FIRE STRATEGY REVIEW REPORT

Project Name: BESS Facility at Knockraha, Co. Cork

Date: January 2026

Client:	Noriker Power
Document No:	252749-ORS-XX-XX-RP-FS-001

Drawing file: 1. Planning Drawings / NPL_KNK_Site-Layout-MAP-A_3.5_P.pdf

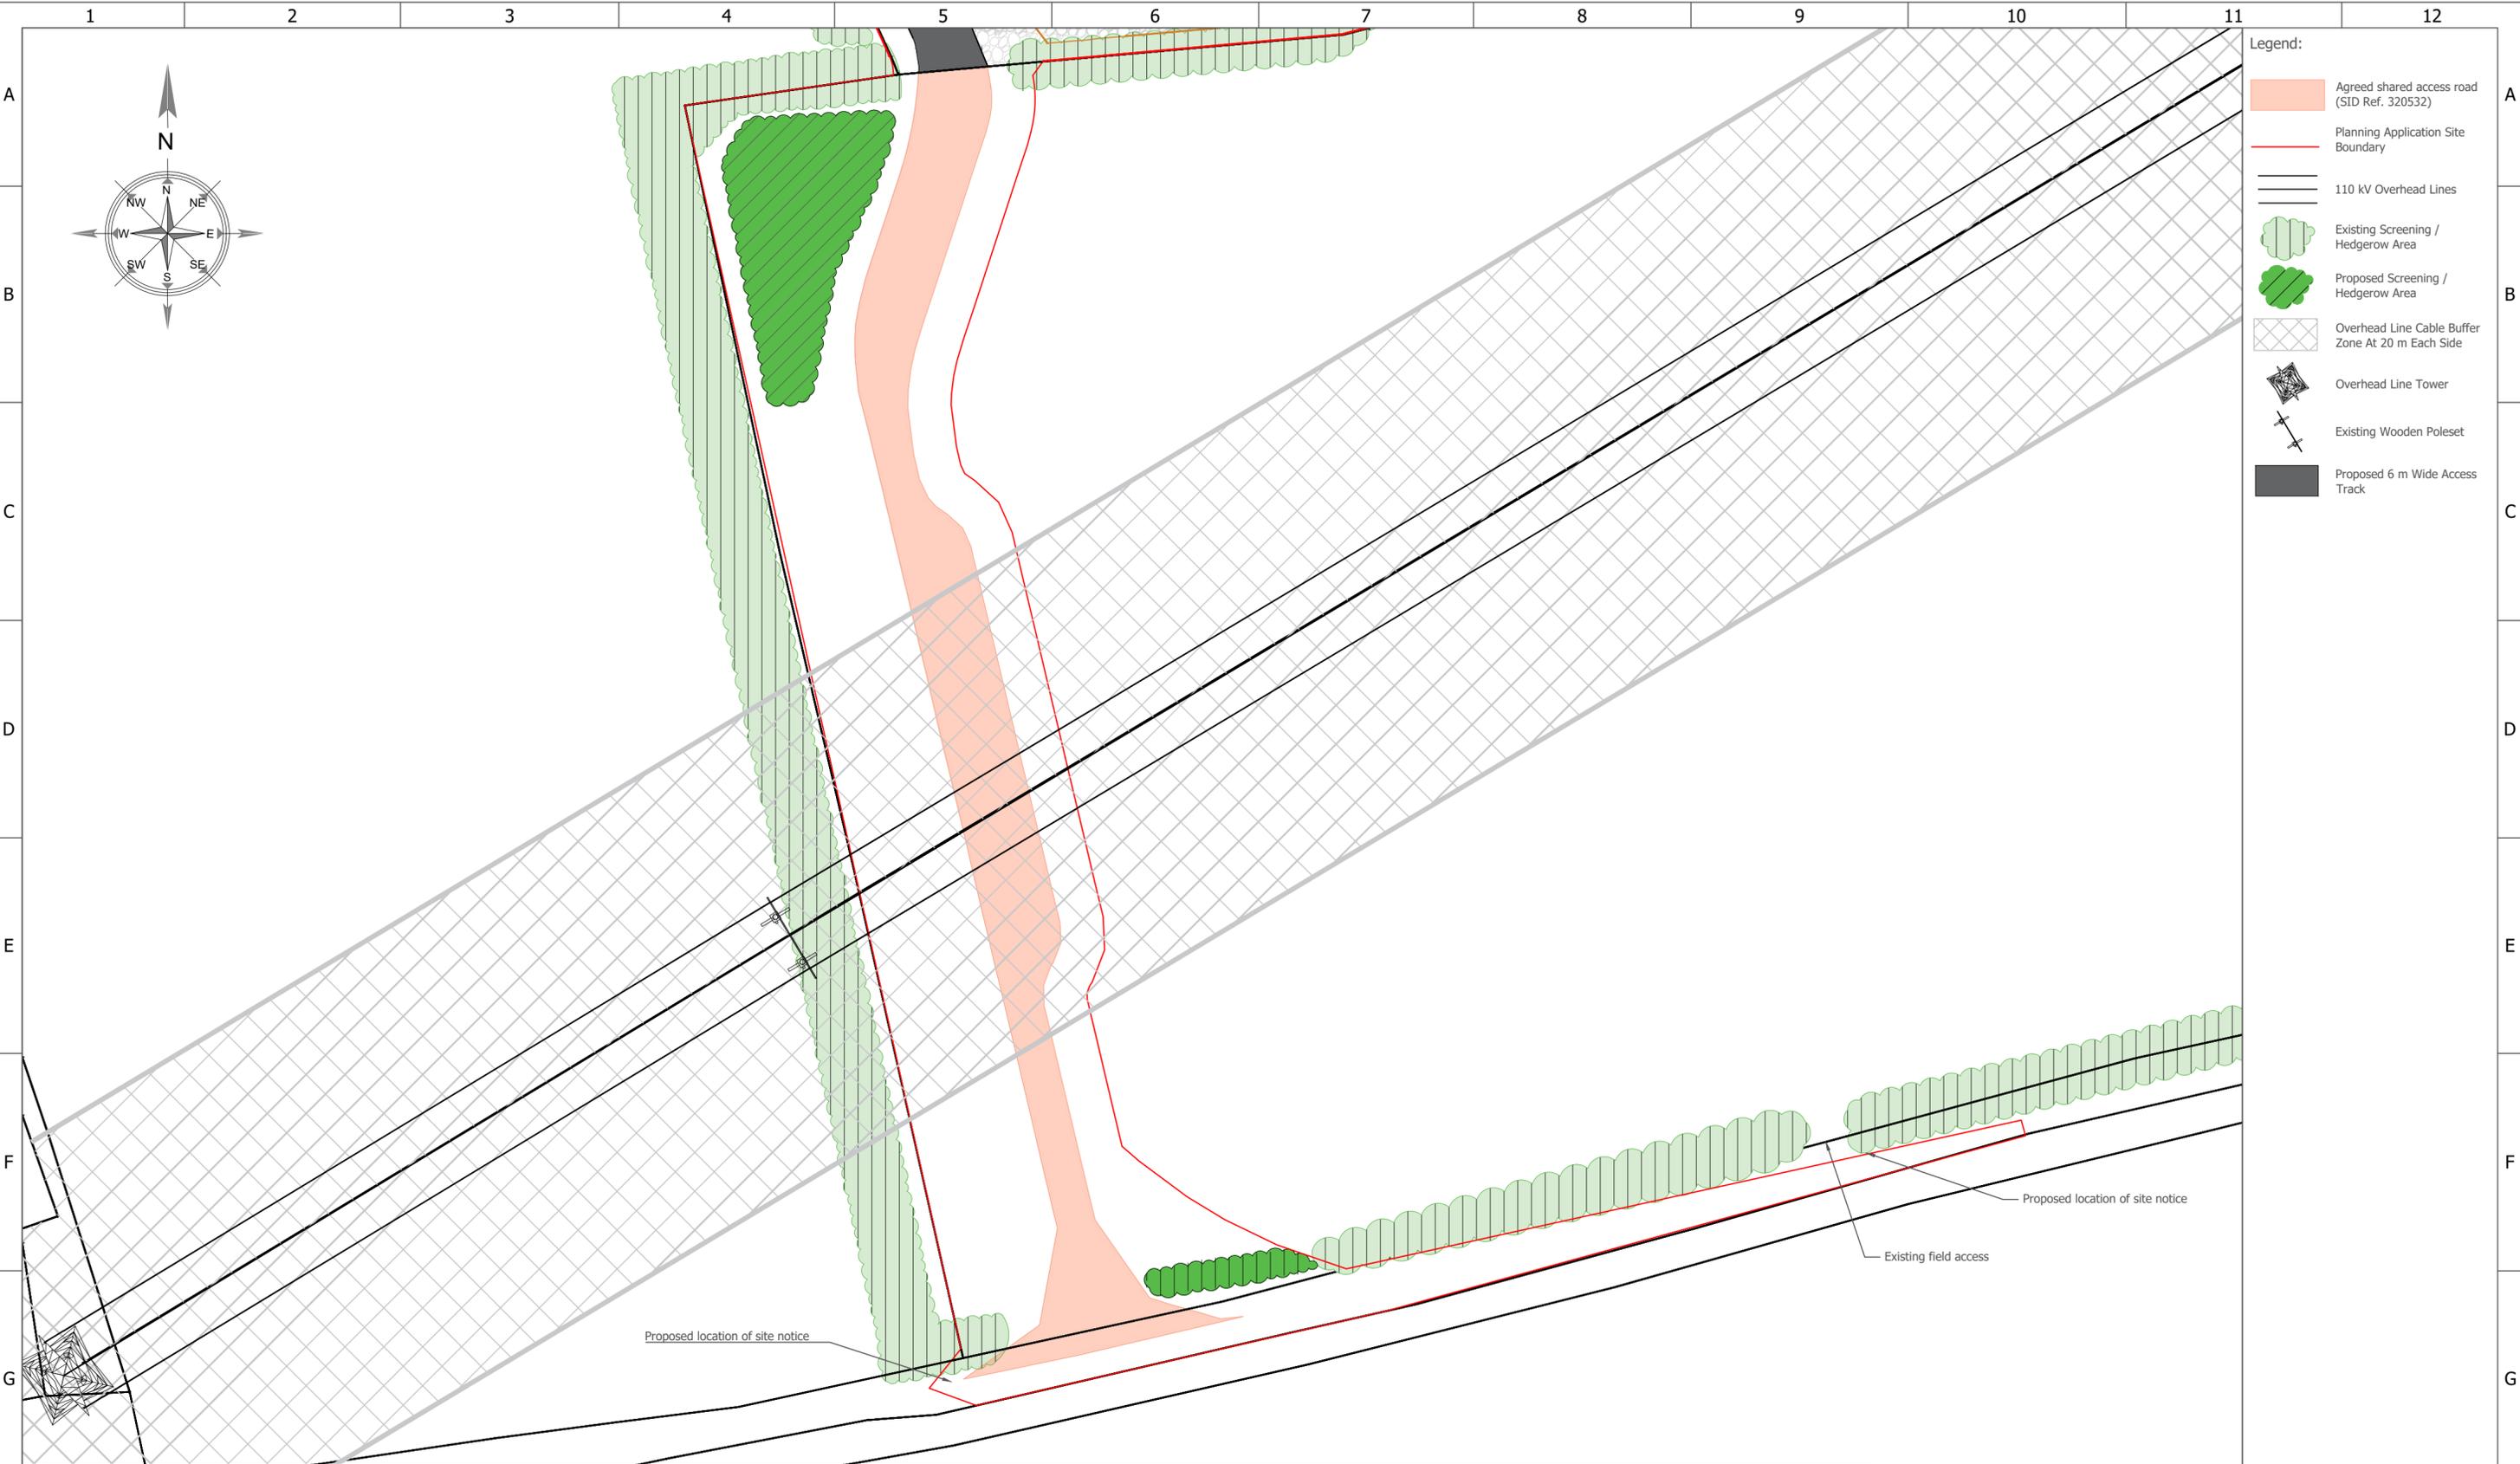
The revised BESS site layout provides a more functional arrangement for fire brigade access, incorporating an interconnected internal road network that allows for unobstructed fire tender access throughout the site. The layout facilitates straightforward manoeuvring and circulation exceeds the minimum access requirements set out in Table 25 of TGD-B 2024.

Provisions for a designated pumping bay are identified on the drawings. Located horizontally adjacent to the reservoir, the updated internal road network offers greater coverage for operations within the BESS site.

Lighting columns are indicated across the site layout. In addition to general site lighting, it is noted that where lighting is relied upon to support escape, emergency lighting designed and installed in accordance with IS 3217:2024 should be considered when determining luminance levels and coverage across the site.

Overall, the proposed BESS site layout provides a well-considered, open, and manoeuvrable arrangement with clear emphasis on access for firefighting facilities. The on-site hydrant strategy (not yet indicated on the drawings) should be distributed throughout the site to ensure that all battery clusters can be accessed by the fire brigade without delay.
